HAYES STRUCTURAL
Consulting & Design, PLLC

Re: 24-FTG-154.1
Structural Analysis
Lot 60 Tobacco Road
19 Grading Stick Court
Angier, NC 27501
Permit No.: SFD2408-0117

At the footing contractor's request, the plans were reviewed for the above referenced single family residence under construction to address the pier footings excavated in the wrong locations.

First Floor Structural Plan
Elevation "B"

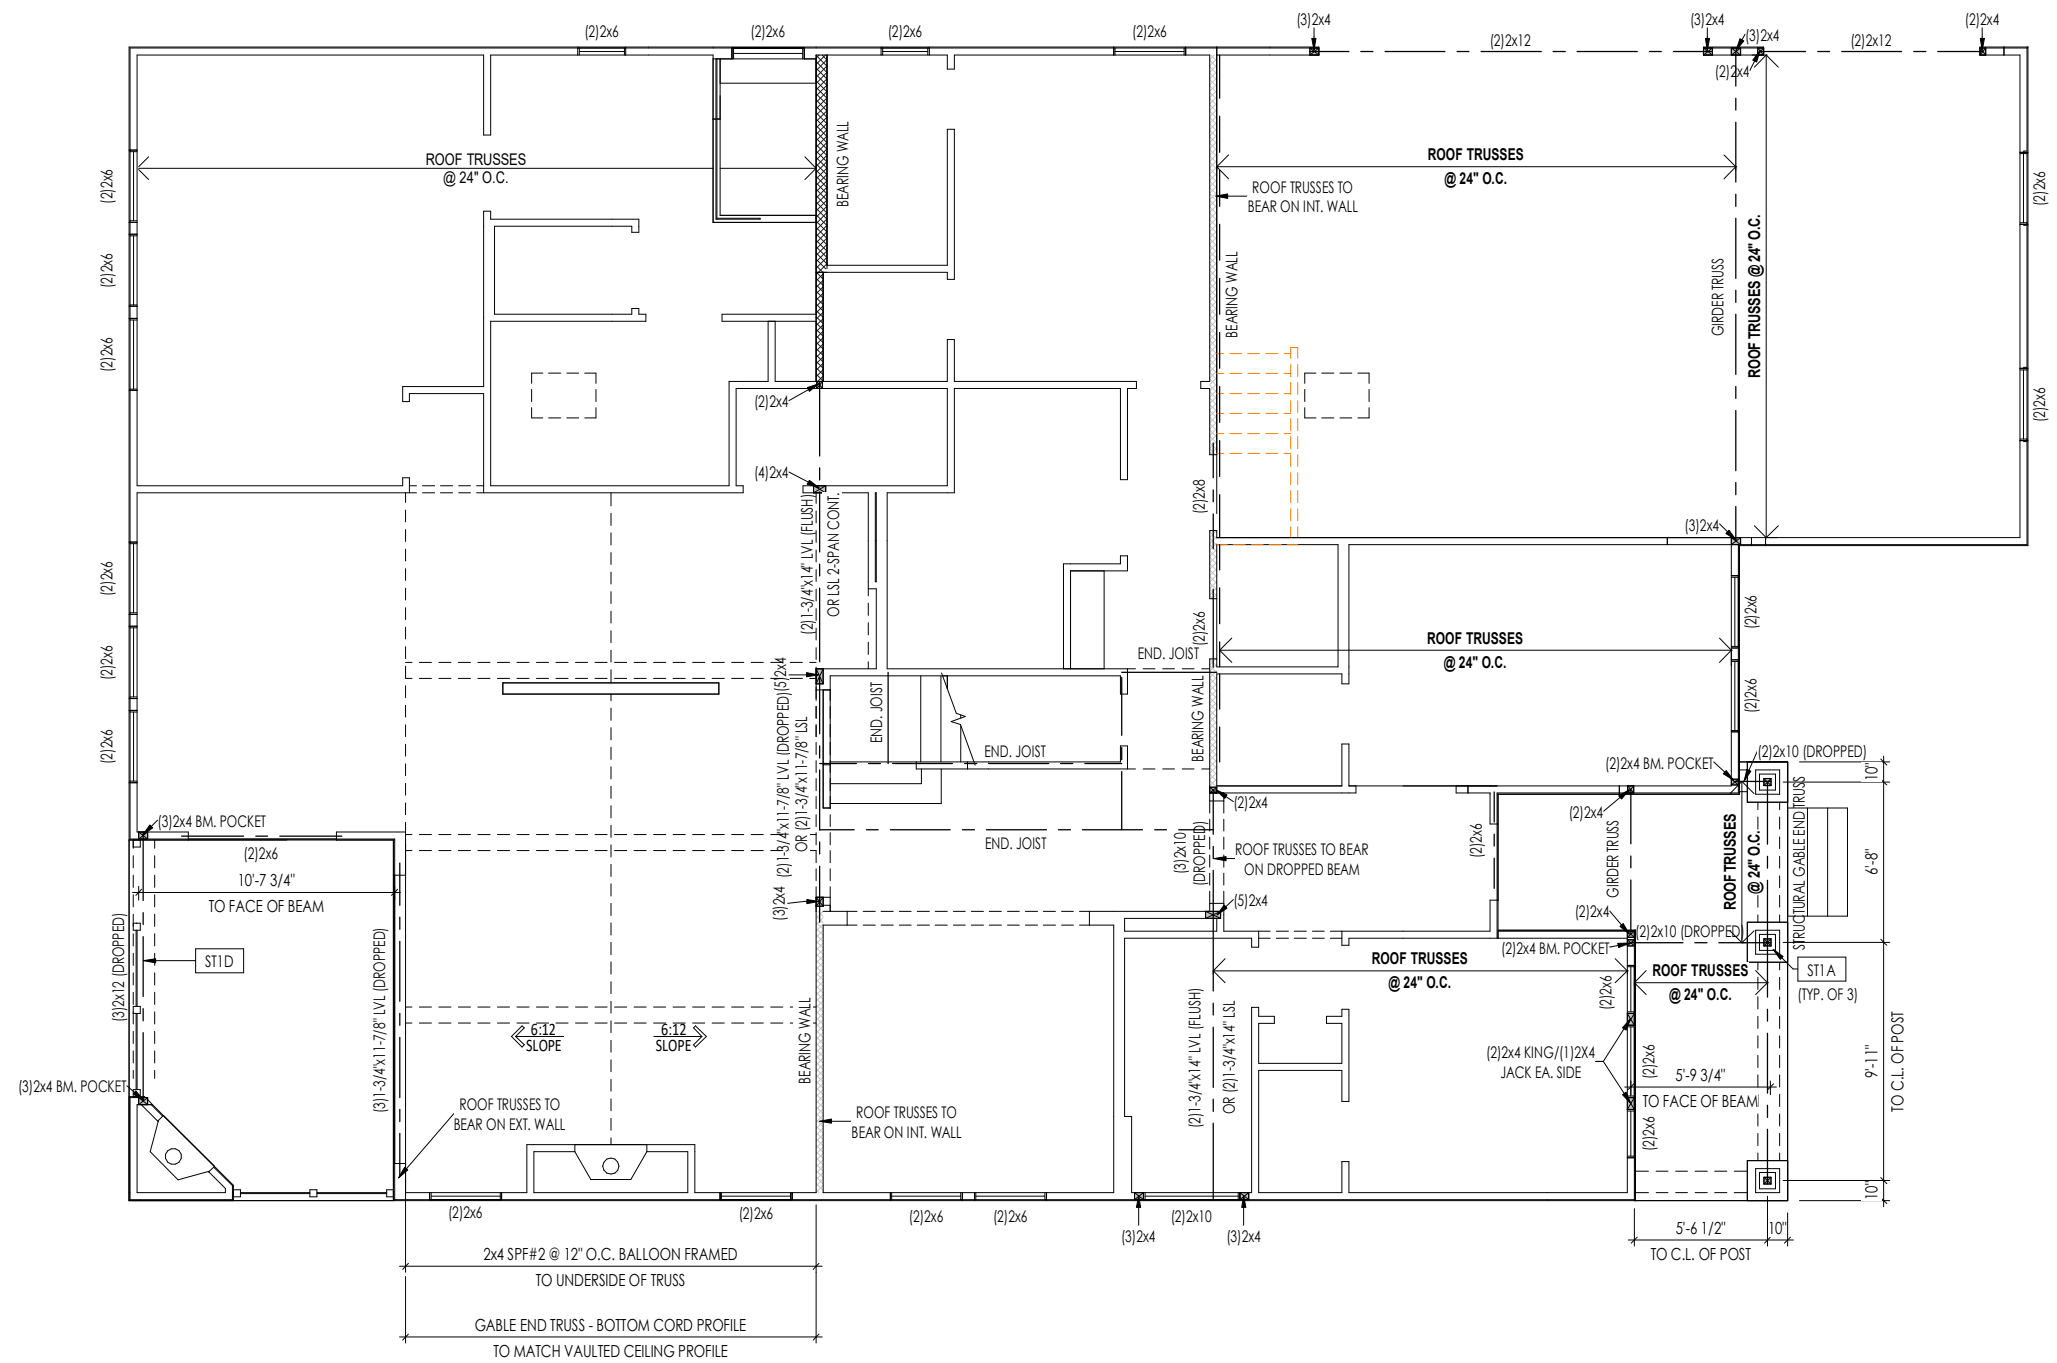
You indicated five of the six footings for the piers supporting the second girder from the rear were excavated in the wrong location. Only the footing for the first pier from the left end of the girder was excavated in the correct location.

Since the footings were over-excavated and backfilled with washed stone, it will be difficult to add onto the existing footings and/or excavate new footings at their plan specified locations. Instead, I recommend constructing the piers within the center one-third of the footings as currently placed. In lieu of the plan specified (3) 2x10 dropped girders, (3) 1 $\frac{3}{4}$ "x9 $\frac{1}{4}$ " LVL dropped girders are required extending from the right foundation wall to the fourth pier from the right side. See the plan snippet on Page 2 for additional information. This prescribed configuration will provide the required support for all imposed loads.
